From:
Sent: 02 January 2024 12:13
To: DCAdmin
Subject: Objection to planning reference 2023/93556

Comments on behalf of the Occupant of 135 Upper Batley Lane, WF17 0QT
a Retired Chartered Structural Engineer.

Proximity of the rear Flat Roofed Section

Rev - : DD-MM-YYYY : Initial : Issue.
Drawing Number 23-110 - P - 03

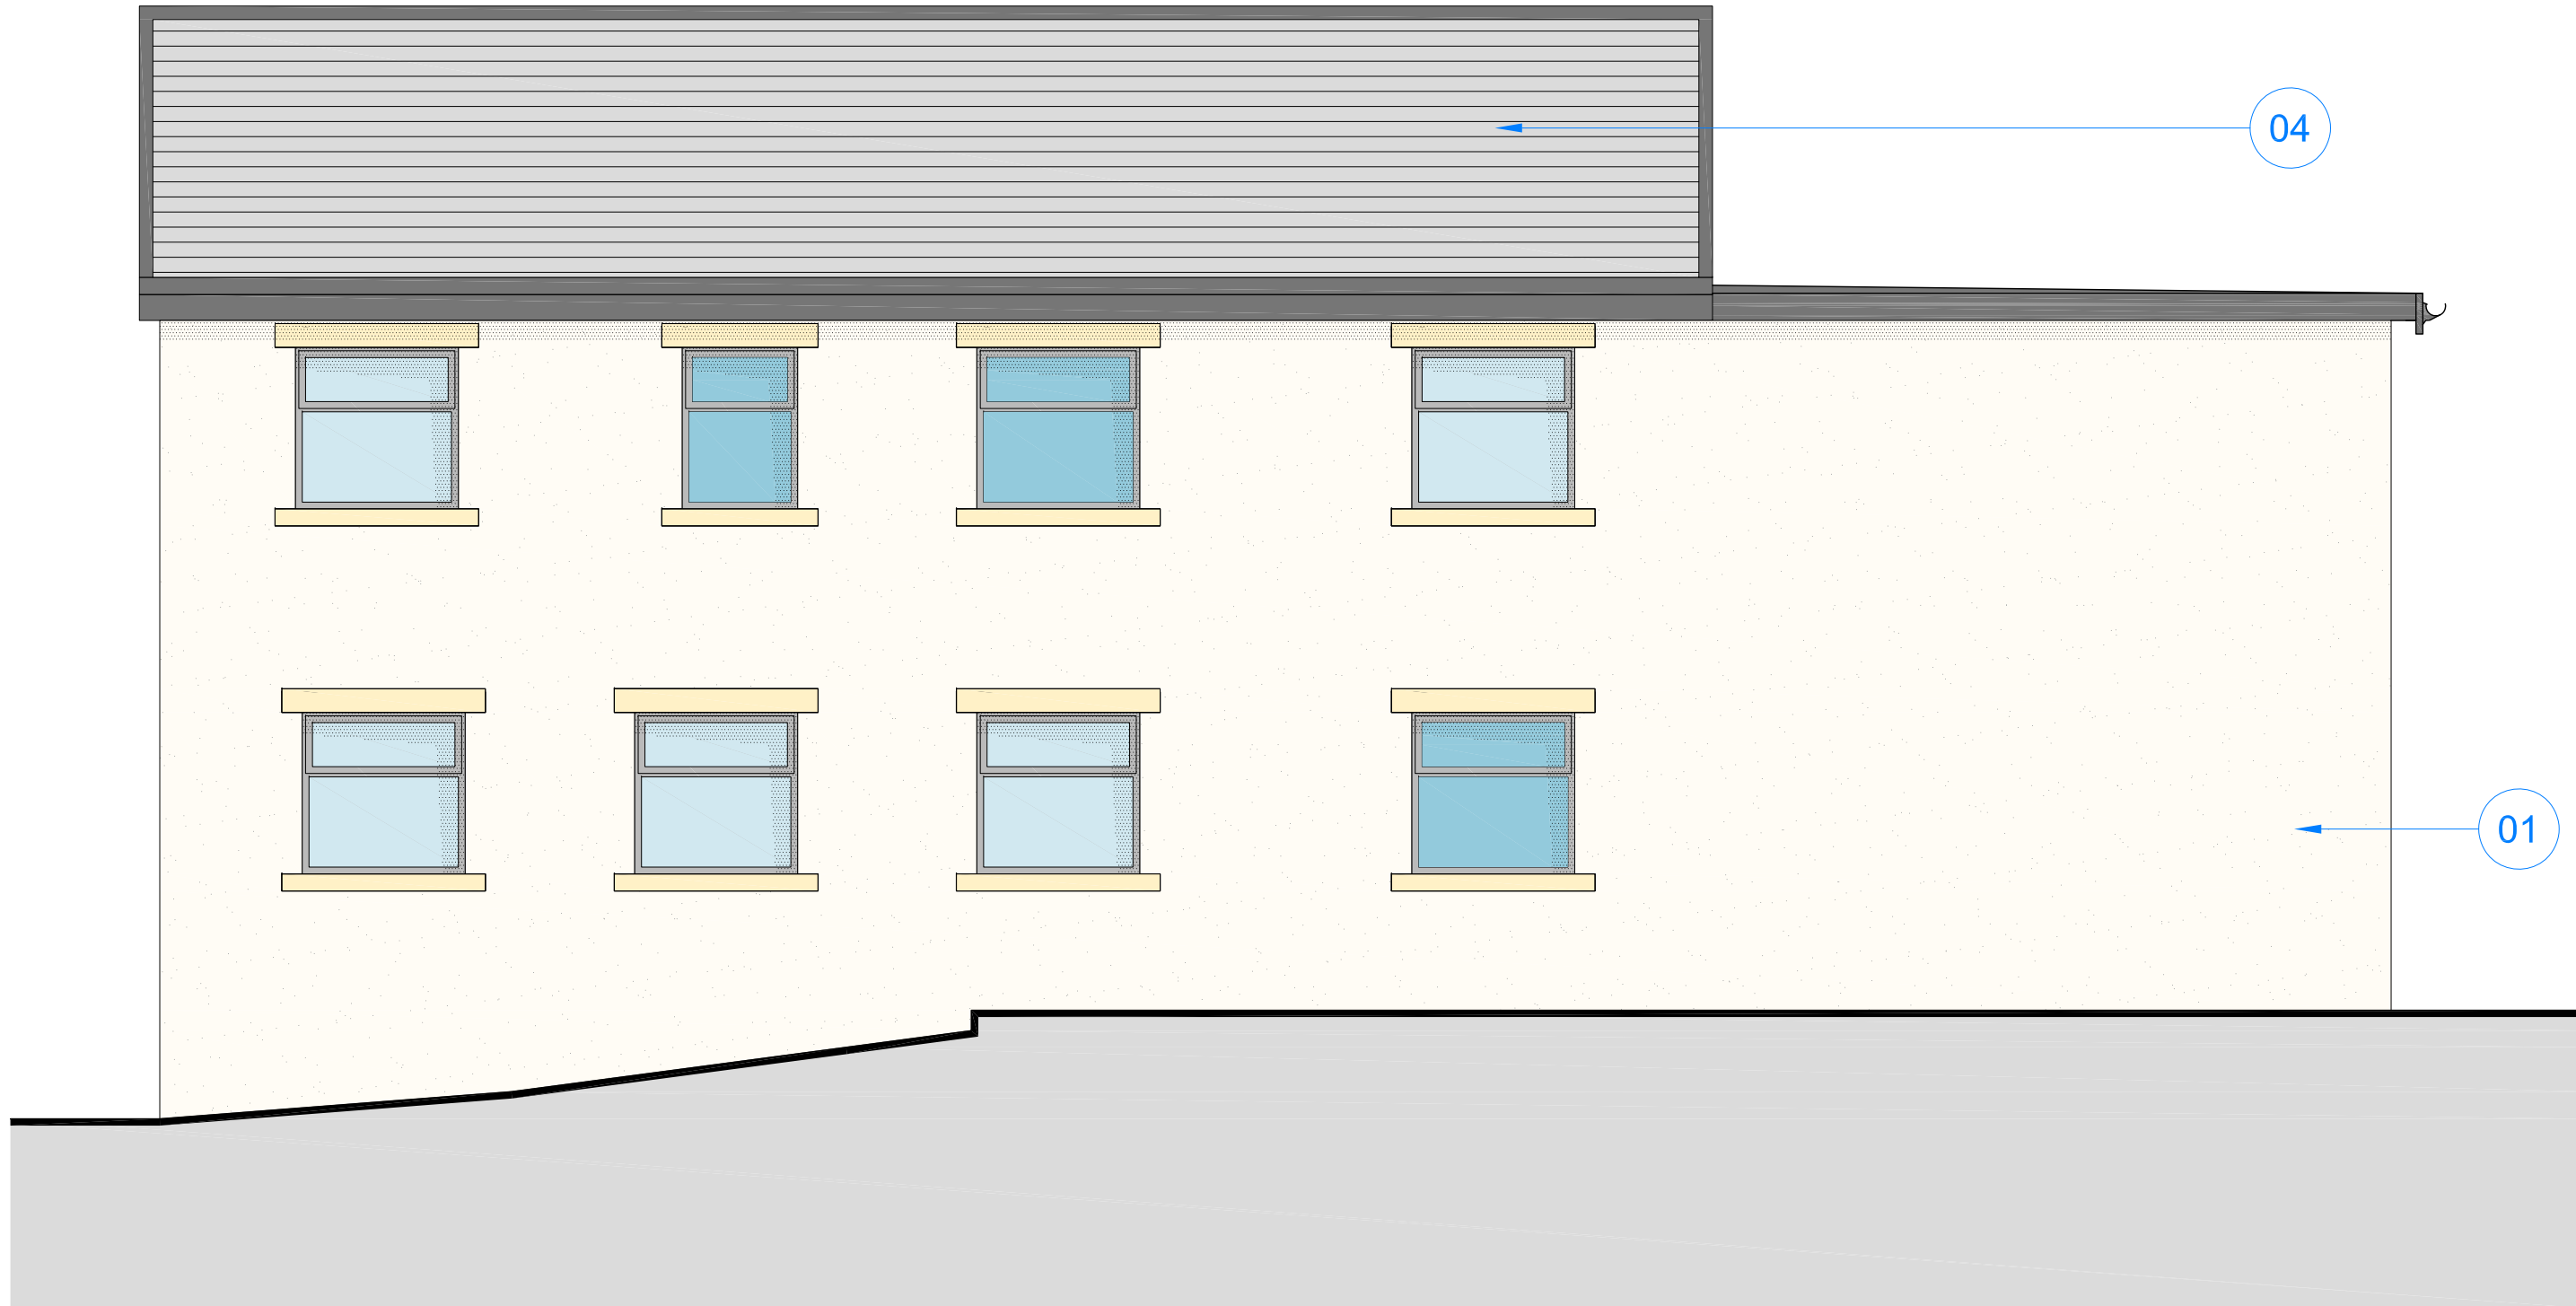
It is apparent from the new ground profiles shown on drg. nos. 23-110-p-02 & 03 that the ground levels are shown to suit the ground floor of the lower building. They are also a lot lower than the levels at the existing boundary and could undermine and disturb the ground in that area.

PROPOSED REAR ELEVATION
Scale 1:50@A1

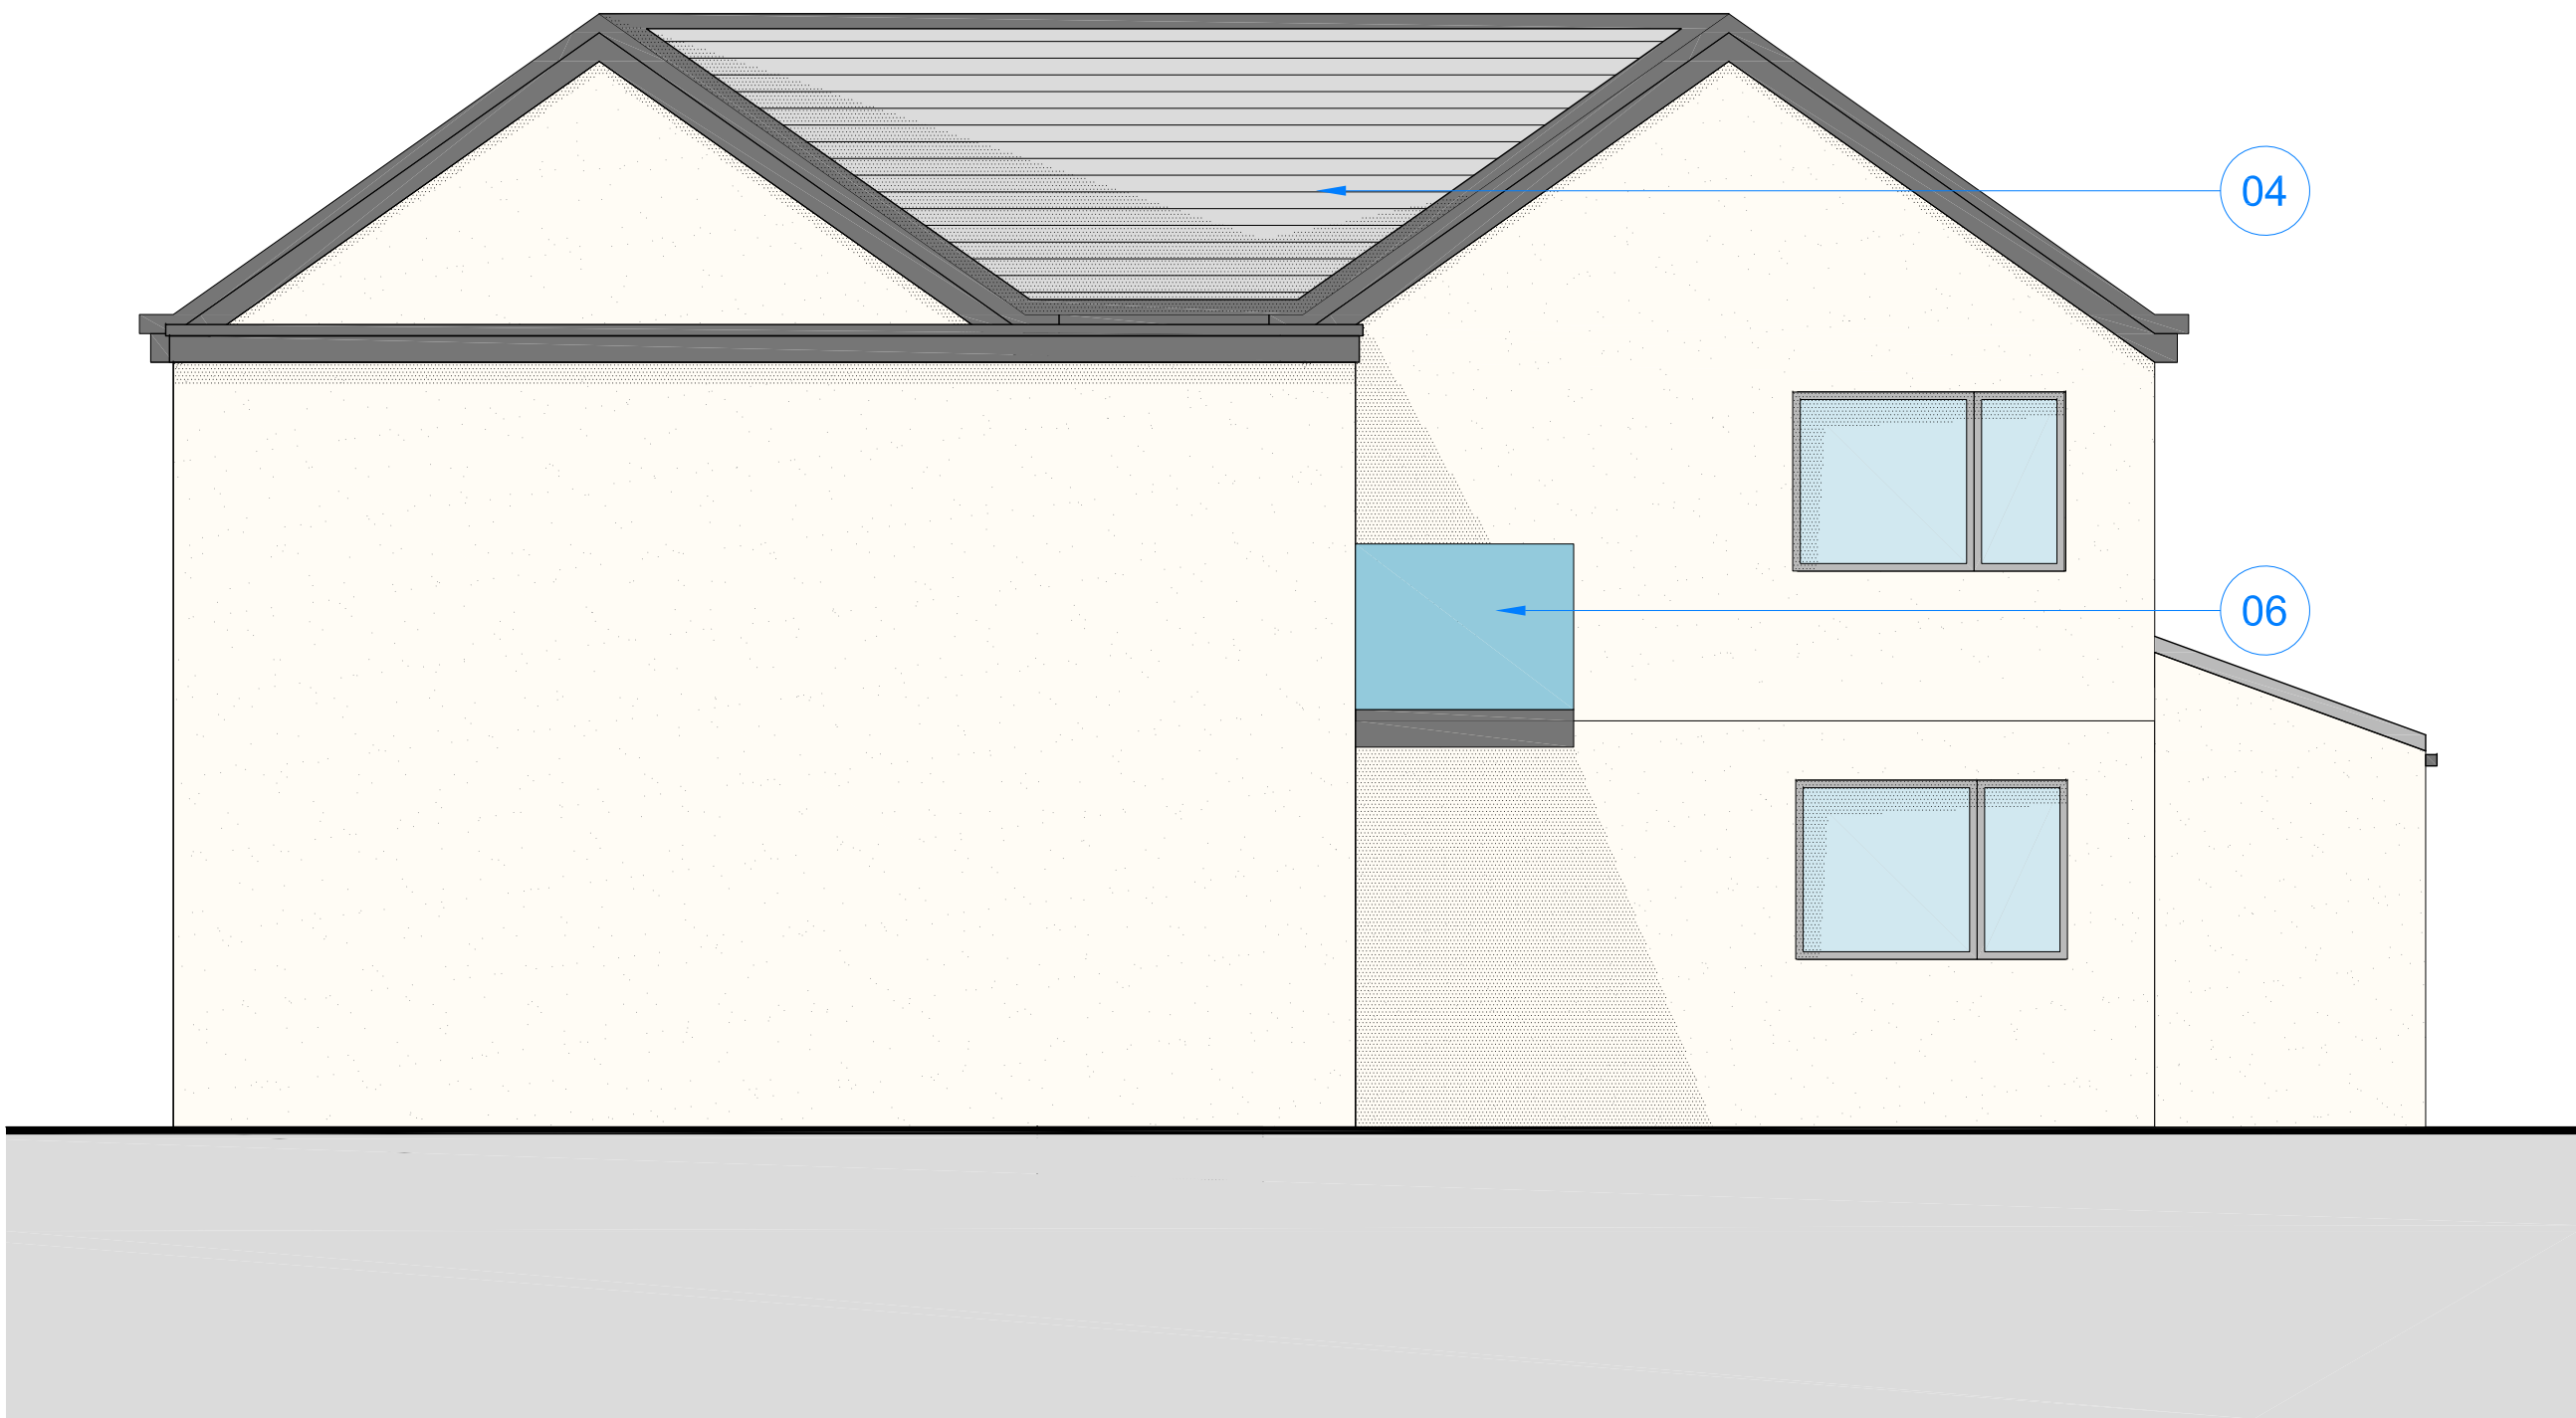
The rear elevation is approximately 8 metres wide and 7.4 metres high (160% bigger than present) blocking out the sunlight in the rear garden of 135 Upper Batley Lane.

The height of the flat roof appears to be about 1200-1800mm above the garden hedge and so close you could touch it. The roof structure would be nearly 2.5 metres high above the path to no. 135.

The level of the balcony means that anybody standing on the balcony can easily see over the hedge into the lower garden of No. 135.

We strongly object to the provision of this balcony as it is too near to the garden to 135 Upper Batley Lane and their privacy will be severely affected.

Even if the balcony was removed the upper windows to the flat roofed extension would have the same effect.

In my view if the ground profiles and the extension at the rear were reconstructed as indicated on the drawings a proper retaining wall will be required to be built by the applicant bearing in mind the soil and drainage conditions and a builder must ensure that the stability is maintained at all times. This wall should be properly designed by a qualified Structural Engineer to well known structural principles who should supervise its construction.

Rev - : yyyy-mm-dd : Initial : Revision Notes
Drawing Number 23-110- P - 02

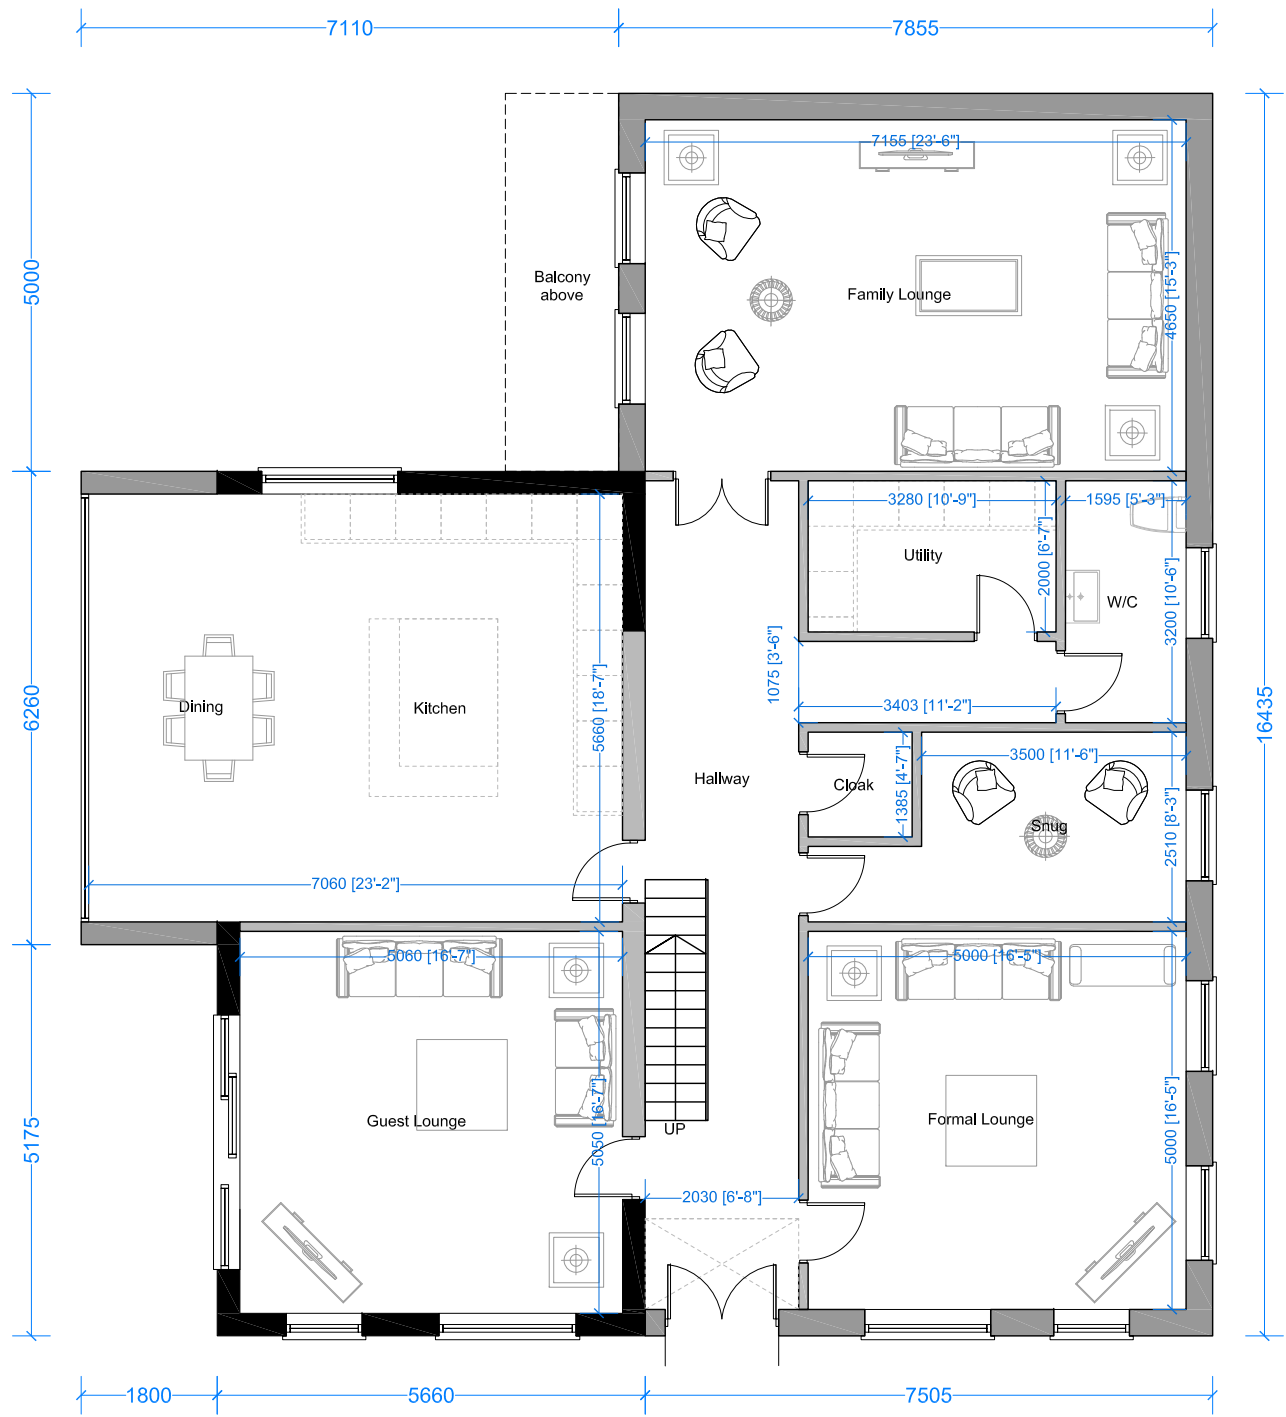
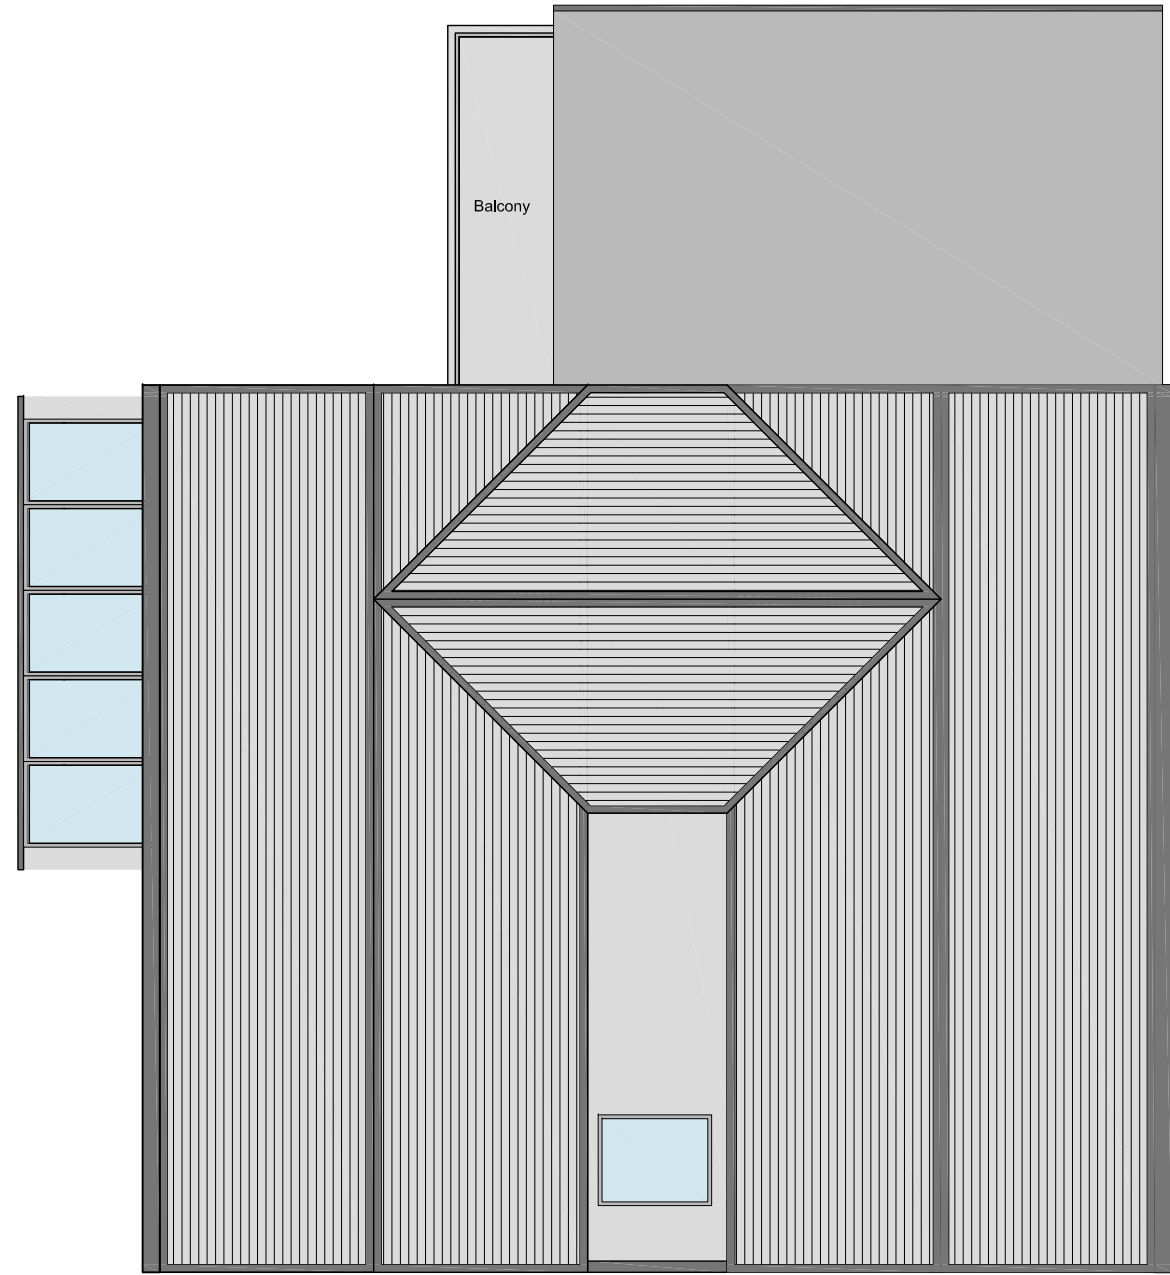
The ground levels indicated on the plans are shown at a the ground floor level of no. 216 which seems to indicated the gardens levels will be changed. This may have a detrimental effect on the whole of my boundary wall and I have asked a relative to look at it.
